Ribble Valley Borough Council
Council Offices,
Church Walk,
CLITHEROE,
Lancashire,
BB7 2RA

TOWN AND COUNTRY PLANNING ACT 1990

Application Ref 3/2019/0545

Proposed mixed use development land between Clitheroe Road and A59/A671 roundabout junction, Barrow

00 - Ground Floor
1 : 100

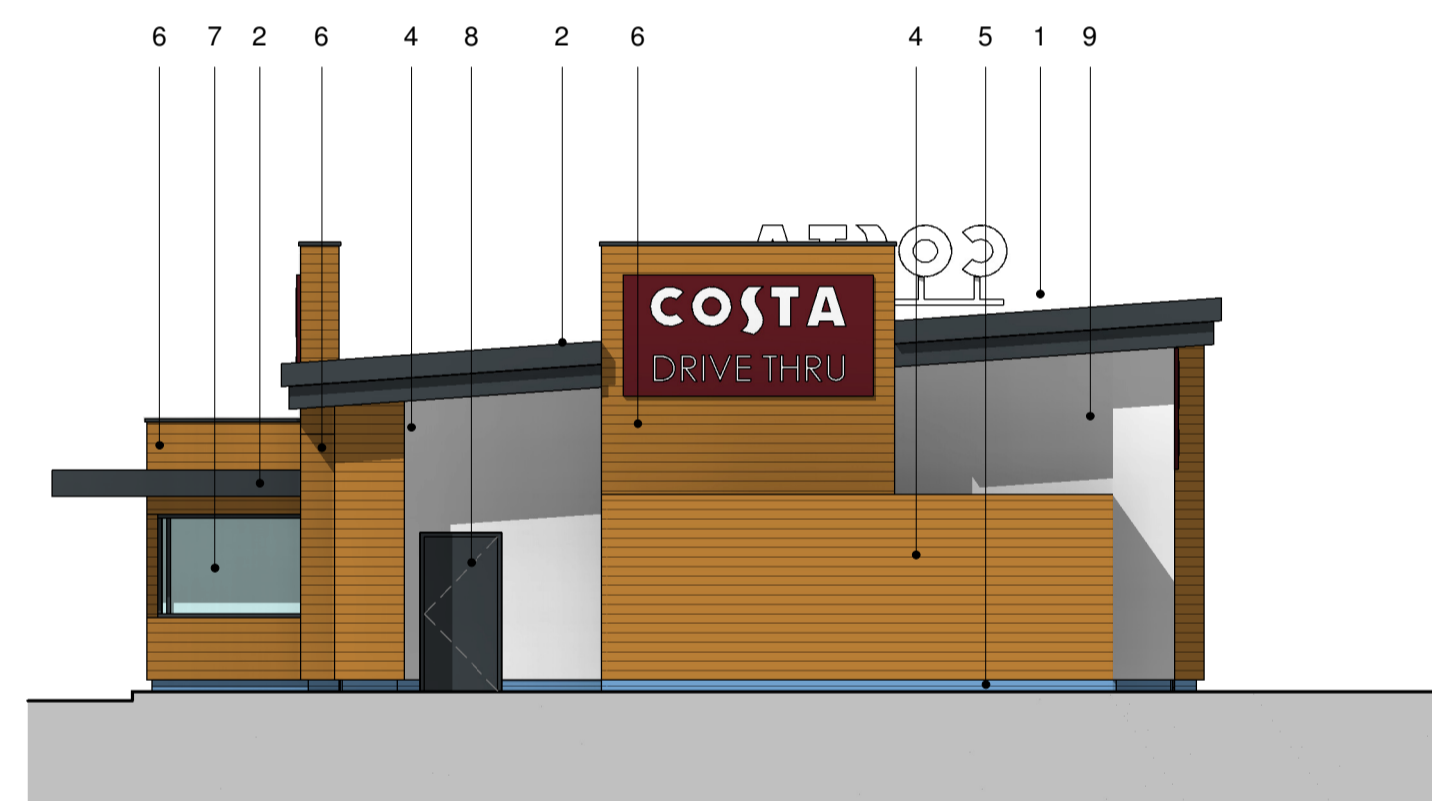
The swept paths for the 'Drive Through' for the purposes of delivery/waste collection does appear to be very close to parking bays which are 4.8mx2.4m (these are historic sizes and do not necessarily satisfy large cars/SUV's or vans), this does not allow for any error by the delivery/waste collection driver and requires cars/vans to be parked within bays which is unlikely. I note that a 10.2m service vehicle has been used, I am aware that a number of LPA's are now using an 11m vehicle for waste collection. This needs to be confirmed as well being suitable for commercial collections. No swept path have been produced at the access (in and out). Right turn storage is required on the link road into the drive through.

As the site is close to the A59 which is used by many medium/large vehicles, no provision is proposed to support these drivers accessing the hot food/drink provision at the drive through. This is likely to result in medium/large vehicles parking on the access road.

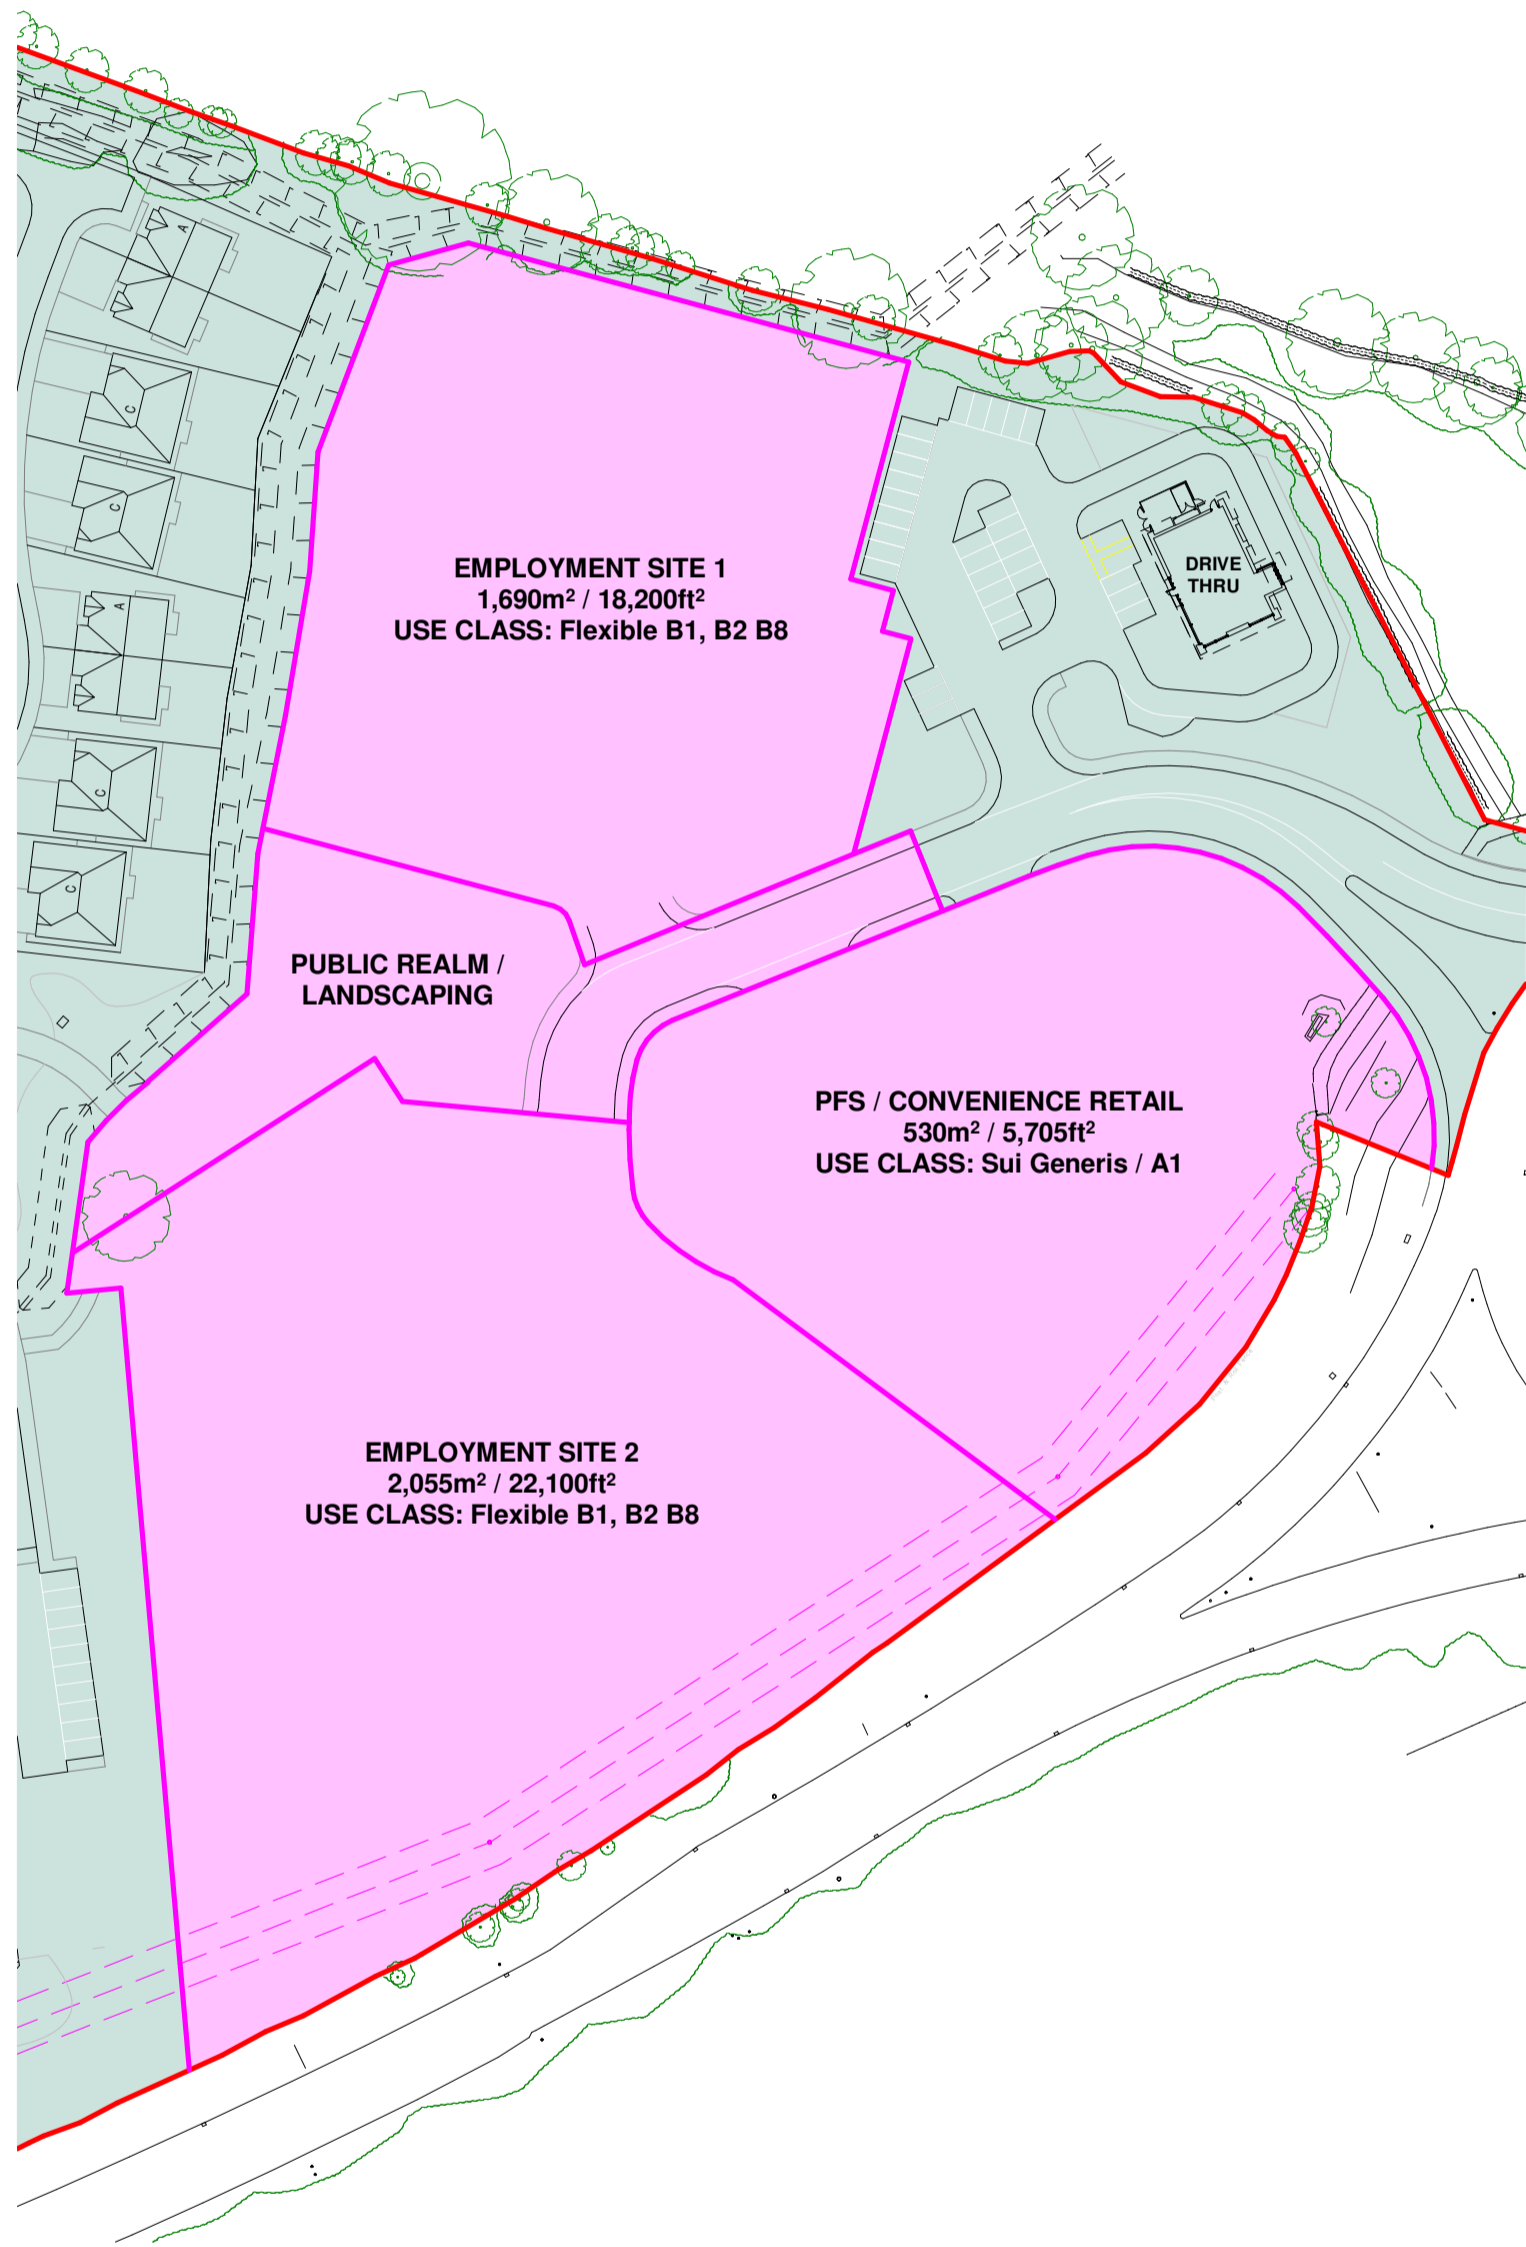
There appears to be limited forward visibility between the PFS exit and exit from units 6-13.

A HGV requires the full road width to access/egress units 6-13. Again a HGV accessing units 1-5+14 will be manoeuvring beyond the centre line with limited forward visibility.

Employment link road through the site with access points as designed will result in conflict within in the site which will impact on the public highway beyond the site. Changes are necessary within.
